Recommendation Report for Planning Permission for Works or Extension to a Dwelling

REF NO: BR/247/20/HH

LOCATION: 9 Waverley Road
Bognor Regis
PO21 5NB

PROPOSAL: Single storey rear extension, single storey side extension and single storey front extension

SCALE - 1/50 REV - B DATE - 16/10/2020

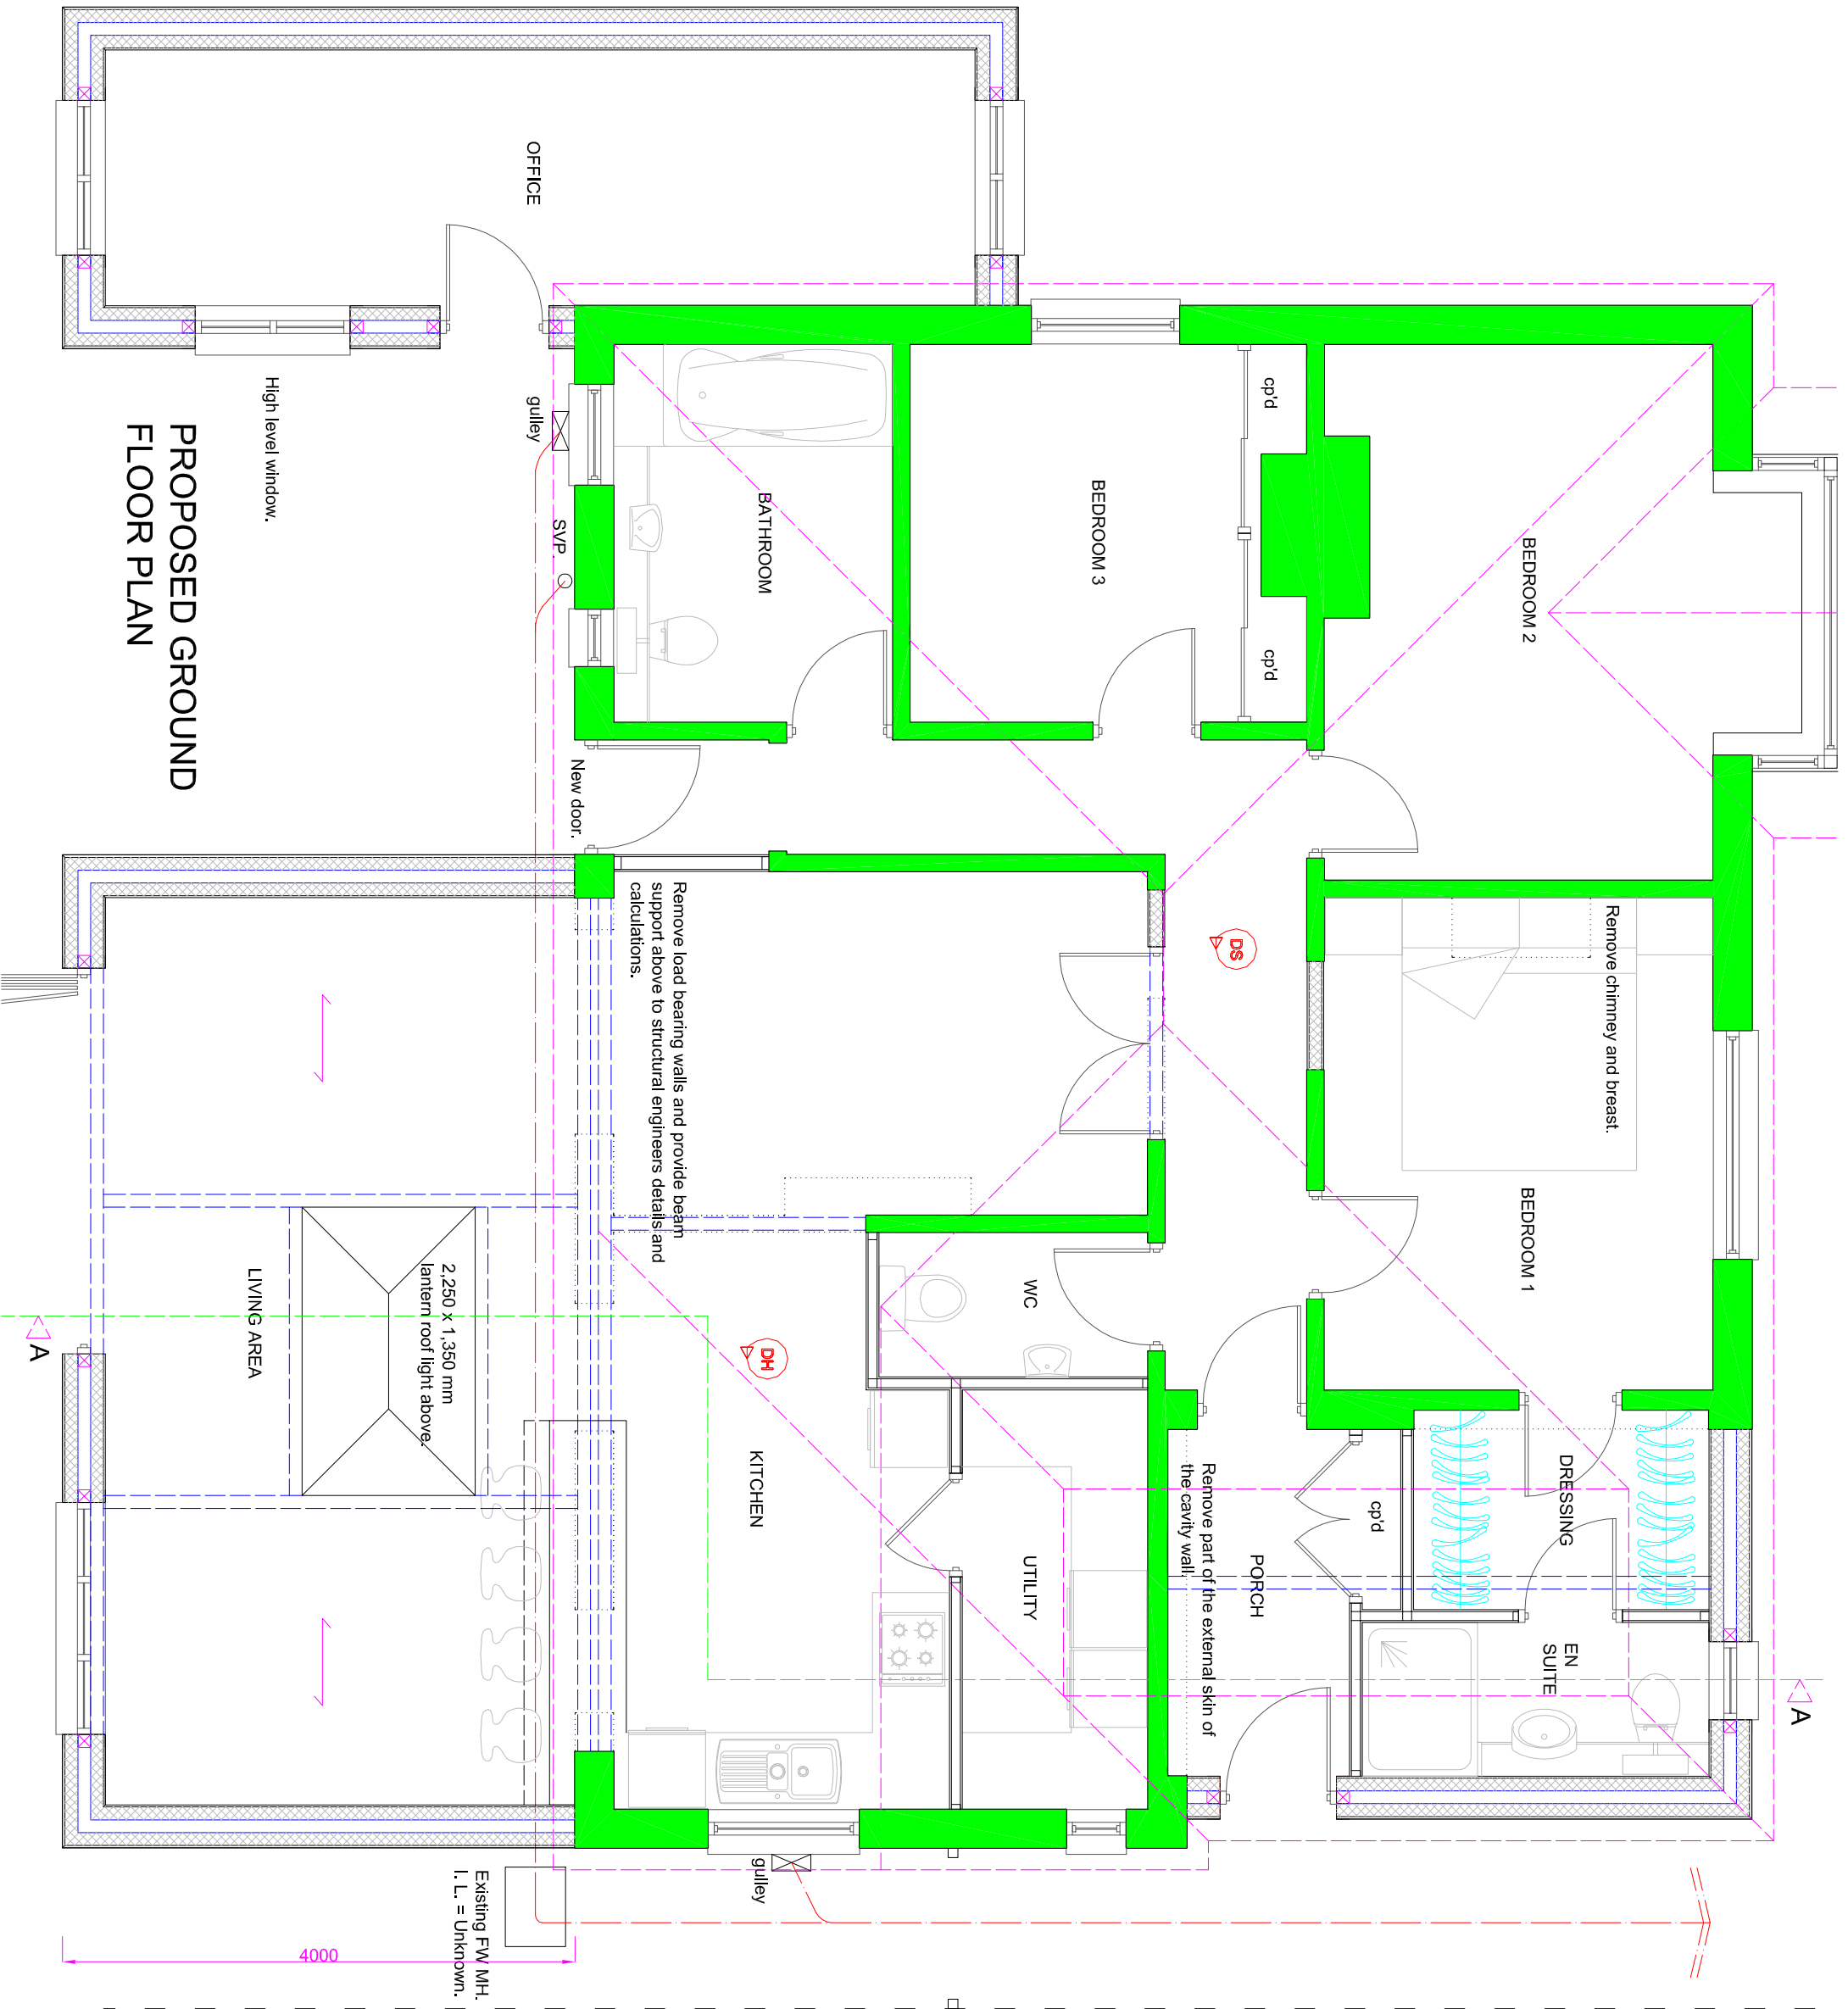
The proposed new fenestration will be located at ground floor level and not gain any views, which are not already visible, as such accord with policy DDM1 and DDM4 of Arun's Local Plan.

PROPOSED ELEVATIONS

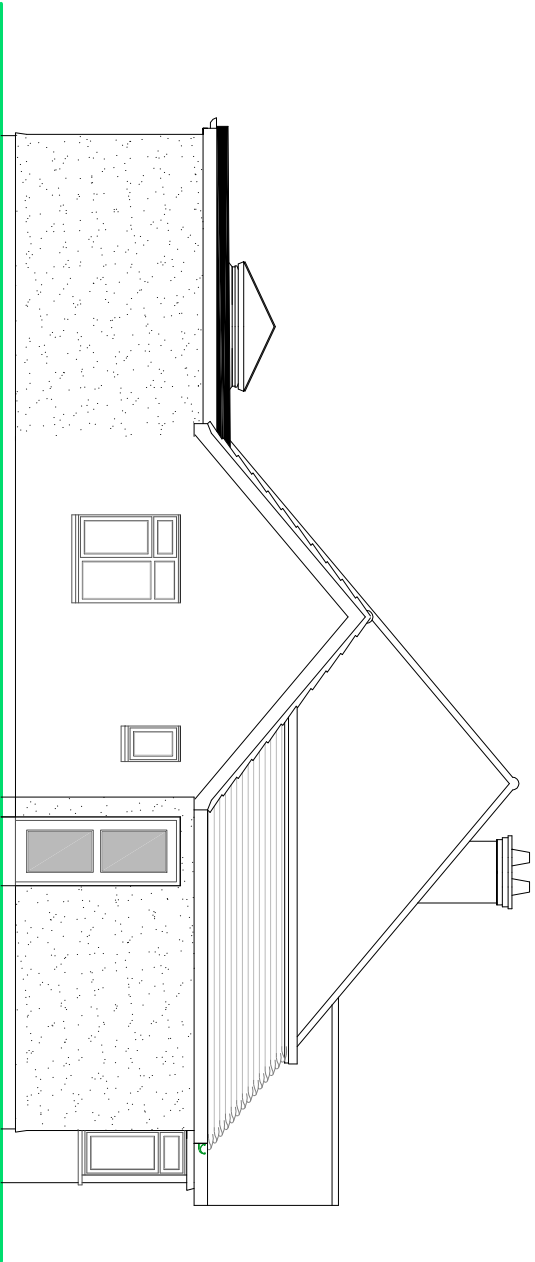
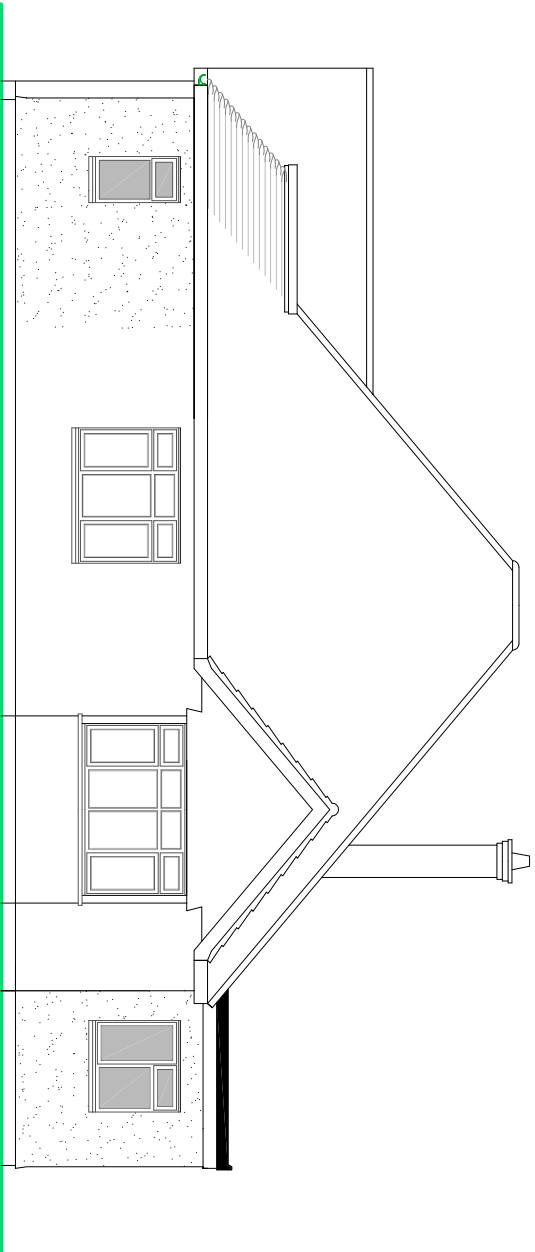
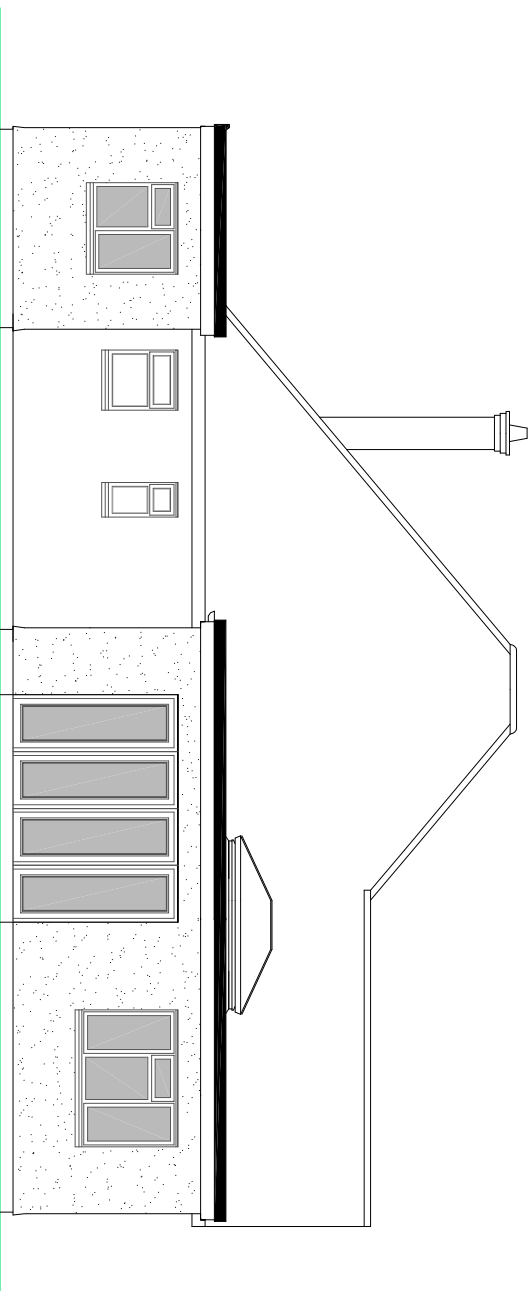
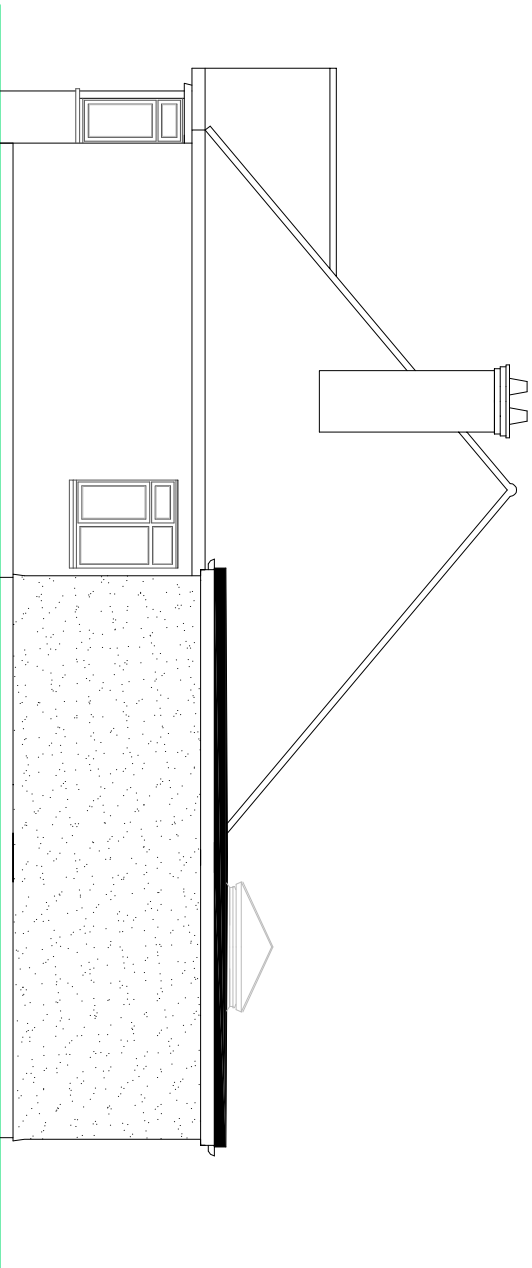
The 3 extensions will be in keeping with the existing property as they utilise materials to match and an eaves height to match the host dwelling. The extension to the front will infill an existing dogleg, it will have a pitch and tiled roof to blend into the existing, with a hidden flat section behind. The side and rear extension will also be visible from the street scene, albeit well behind the principle elevation, and replace an existing garage and as such will accord with D DM1 and D DM4 of Arun's Local Plan.

The scale of the 3 individual extensions are in keeping with the scale of the building. The side and rear extension and the front infill extension will blend into the street scene due to their utilisation of materials to match and incorporation into the existing roof where applicable. As the side and rear extension replaces an existing garage it is not thought that this will negatively impact the neighbour it shares a boundary with. The rear extension and front infill extension are approximately 1.2m away from the boundary to the North and are thought to be a suitable distance away from their respective boundary and as such accord with D DM1 of Arun's Local Plan.

The side and rear extension, which could arguably be considered to have the most impact on neighbouring properties due to its boundary location is a replacement structure and is only proposed to be 300mm taller than the existing structure and is therefore not thought to be a detriment to the neighbours. Neither of the other extensions are perceived to have a negative effect on neighbouring properties nor overshadow neighbouring properties and as such accord with D DM1 and D DM4.
